RESPONSE TO REVIEWER COMMENTS

To: Grace Manahan
City Planner, Mercer Island

RE: 2306-124 SUB1 PLANS
Hong + Kao Residence

SITE PLAN
1/16" = 1'-0"

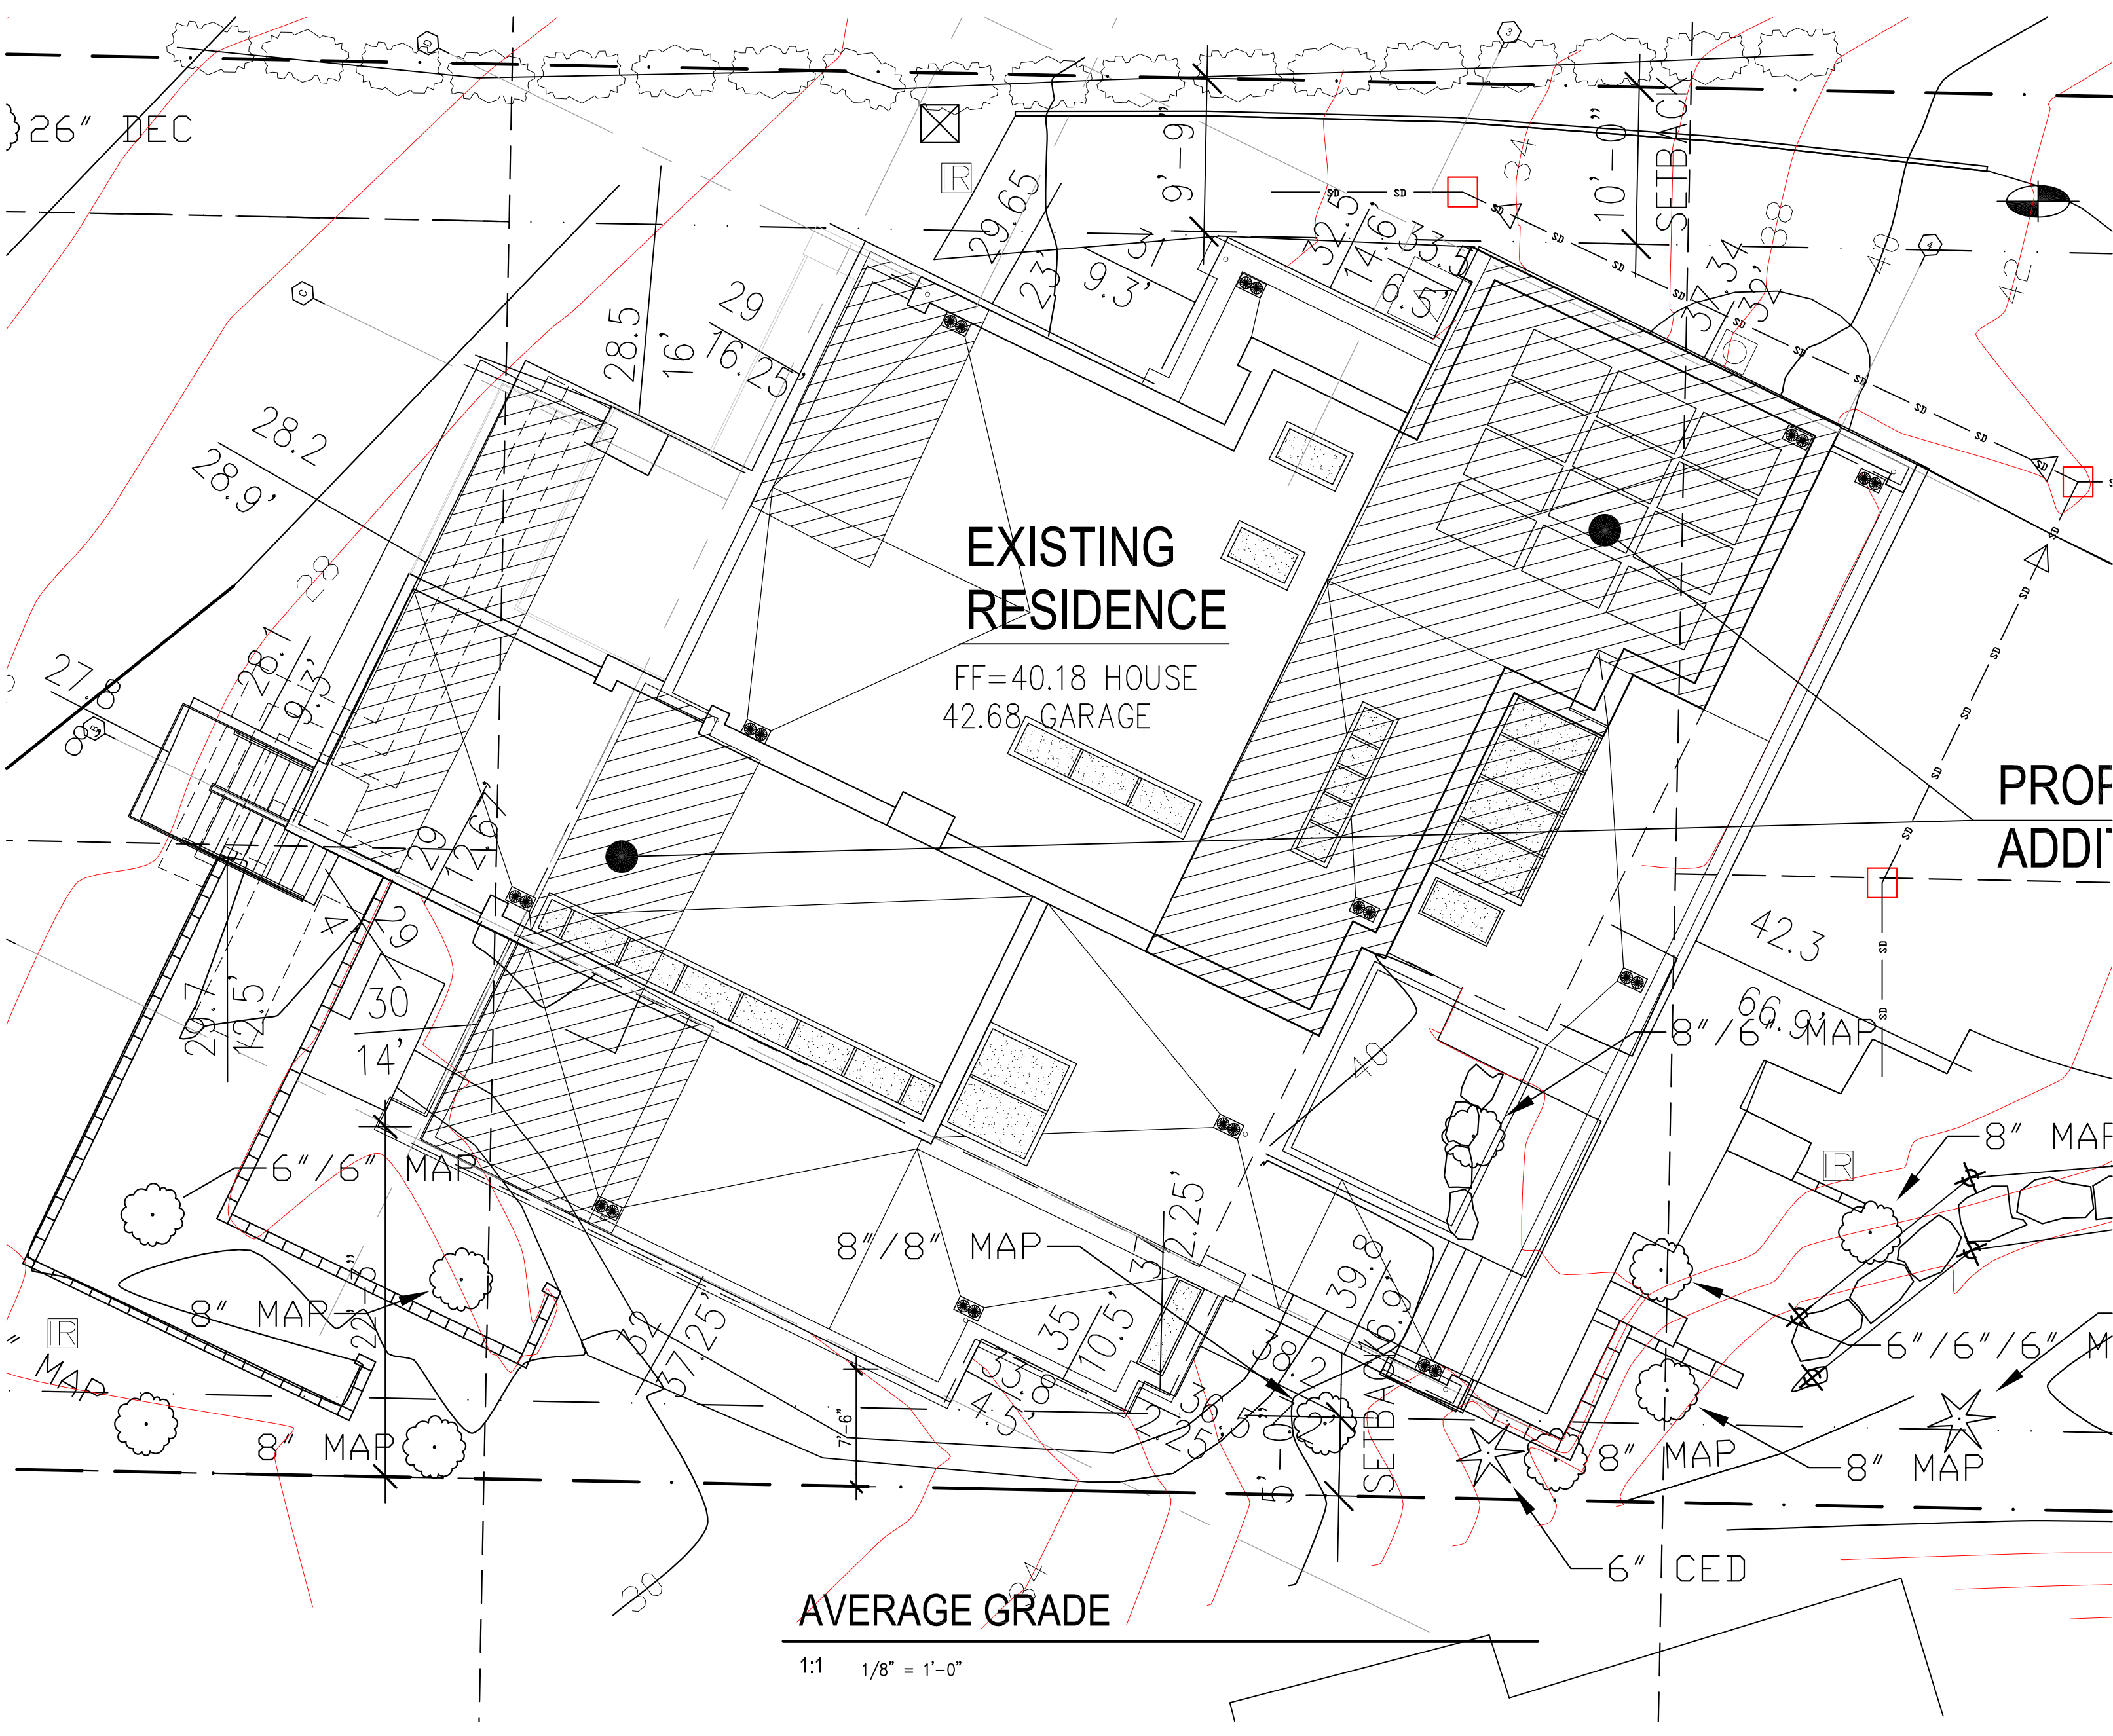
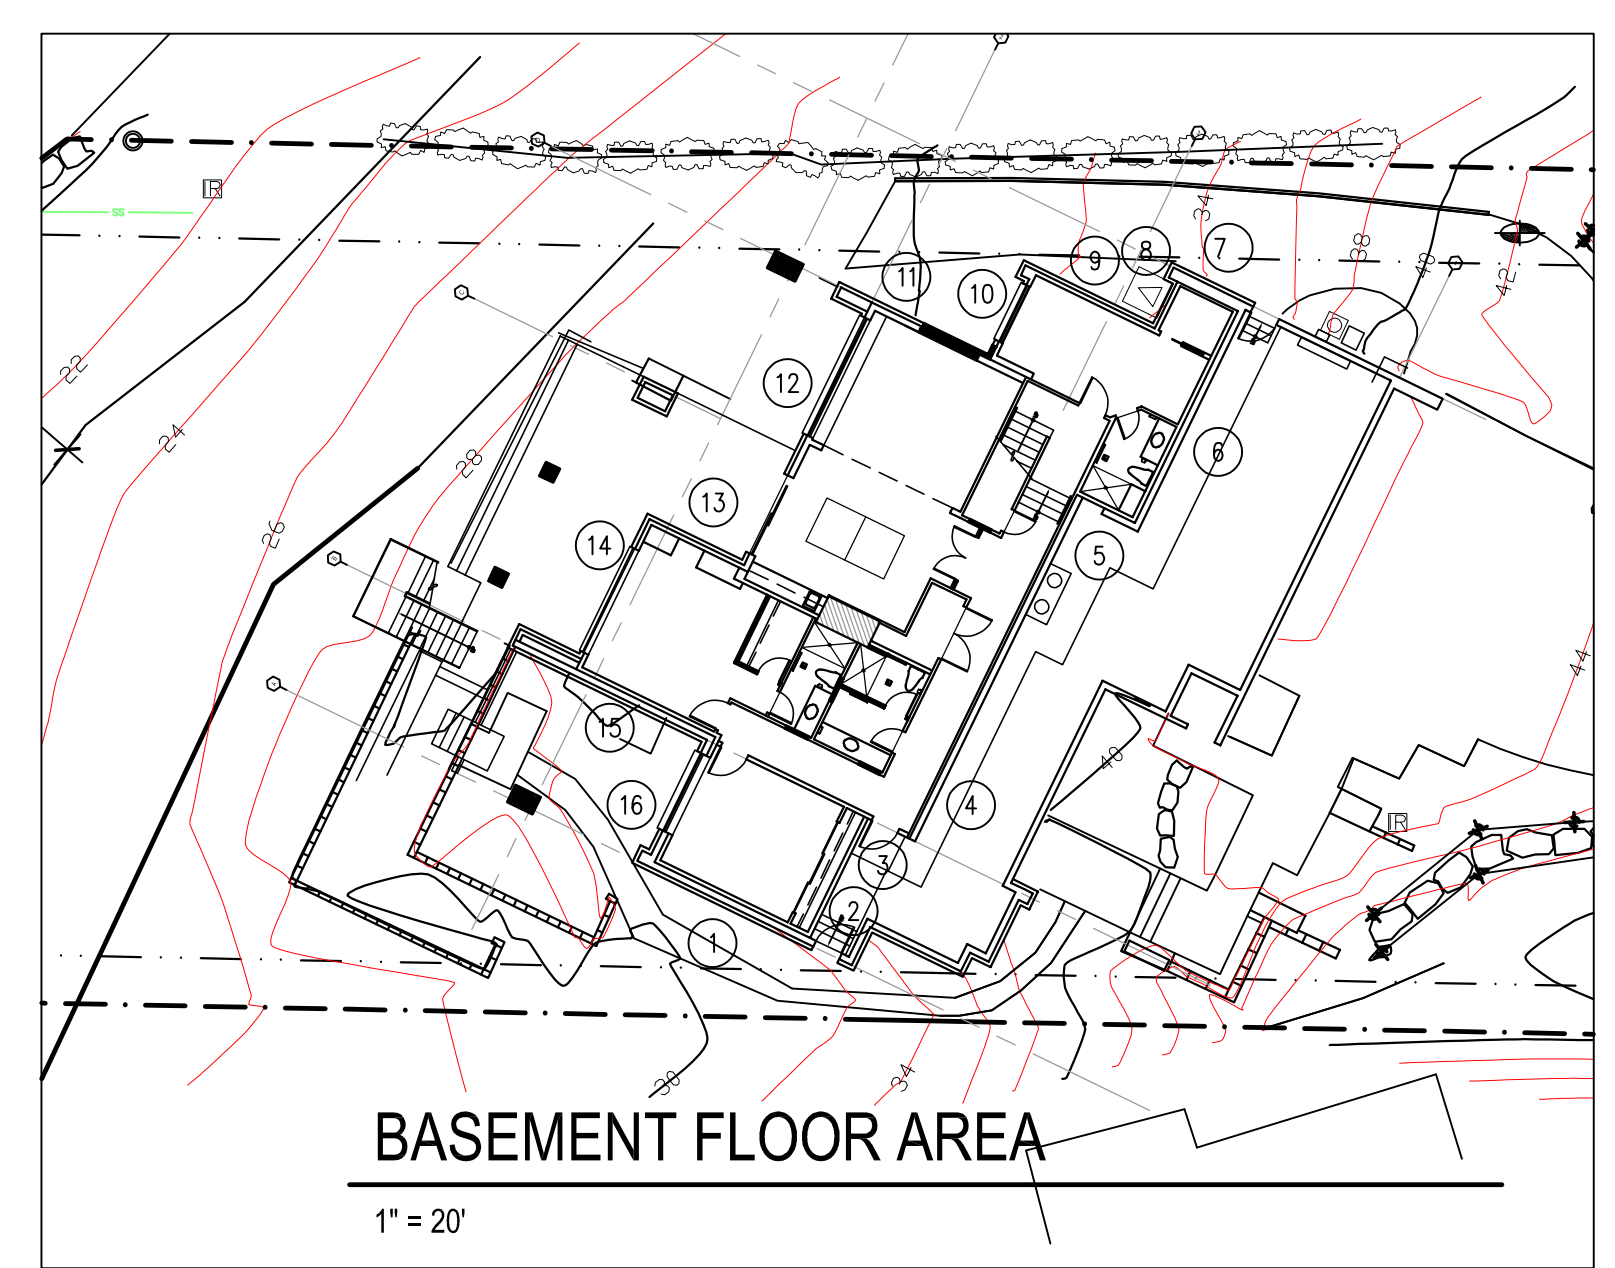
1. Ten foot setbacks.
 - The residence is existing with a ten foot setback on the north and five feet on the south. No changes are proposed on the south side of the residence. The ceiling of the living room is being raised but it is over twenty feet from the south property line.
2. Forty percent.
 - Sheet 1.2 has been added to the plan set illustrating the extent to which the exterior is being altered.
3. Downhill façade
 - The tallest part of the downhill façade are the existing brick pilasters at the upper floor bedroom. No change is planned to these. The west wall of the bedroom is being move 2' west, but is behind the west face of the pilasters. The area supporting the roof is not being changed and is existing non-conforming. The deck is being expanded west but is 25' above the lowest point of the grade. See attached plan and photograph.
